CITY OF PORTLAND BUILDING PERMIT

PERMIT ID: 2013-00186

has permission to **Amendment to permit 2011-10-2535 - adding 42" x 65" landing and stairs on left side.**

Proposed Use: Single Family	Proposed Project Description: Amendment to permit 2011-10-2535 - adding 42" x 65" landing and stairs on left side.
---------------------------------------	--

LANDING & STAIRS

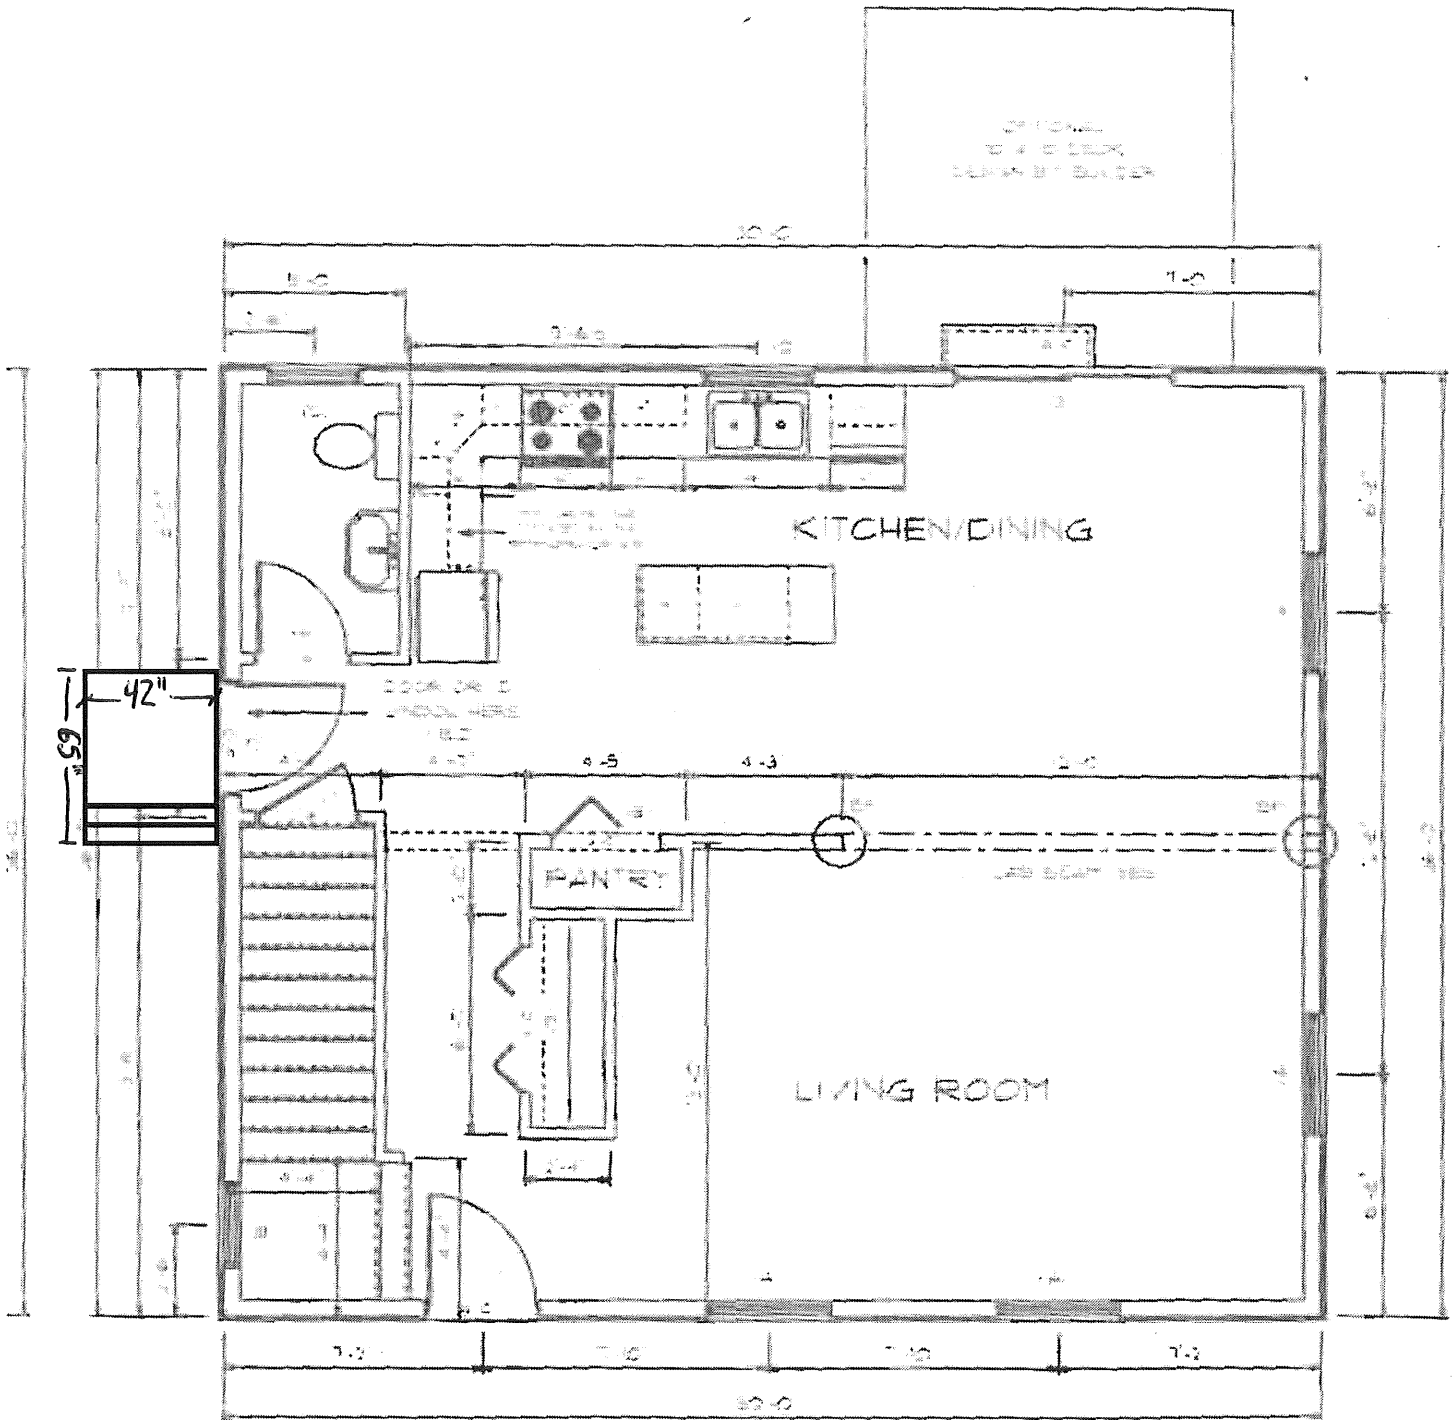
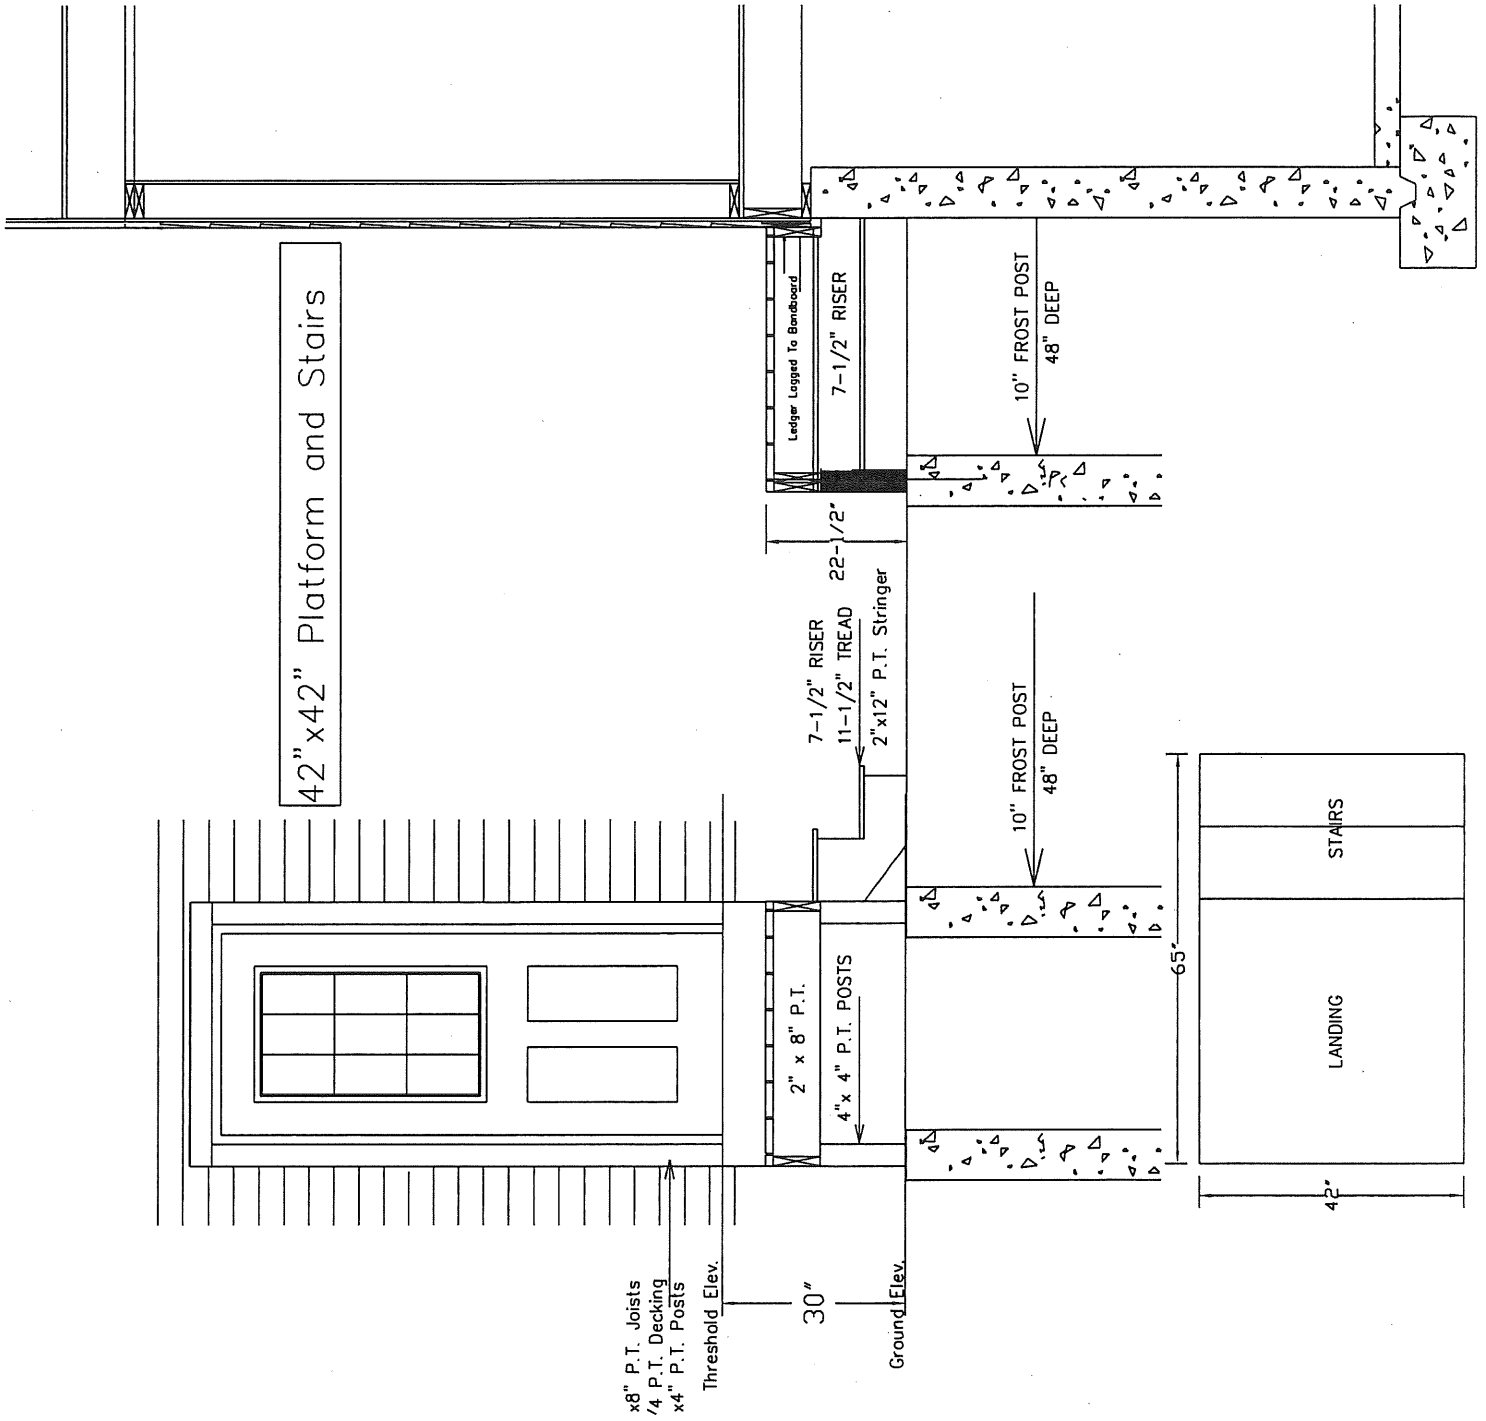
Dept: Zoning **Status:** Approved **Reviewer:** Ann Machado **Approval Date:** 02/04/2013
Note: Side landing and stairs is being approved under section 14-425. The proposed landing encroaches 1.5' into the side setback. The footprint is 19 sf and it extends 3.5' off the building. **Ok to Issue:**
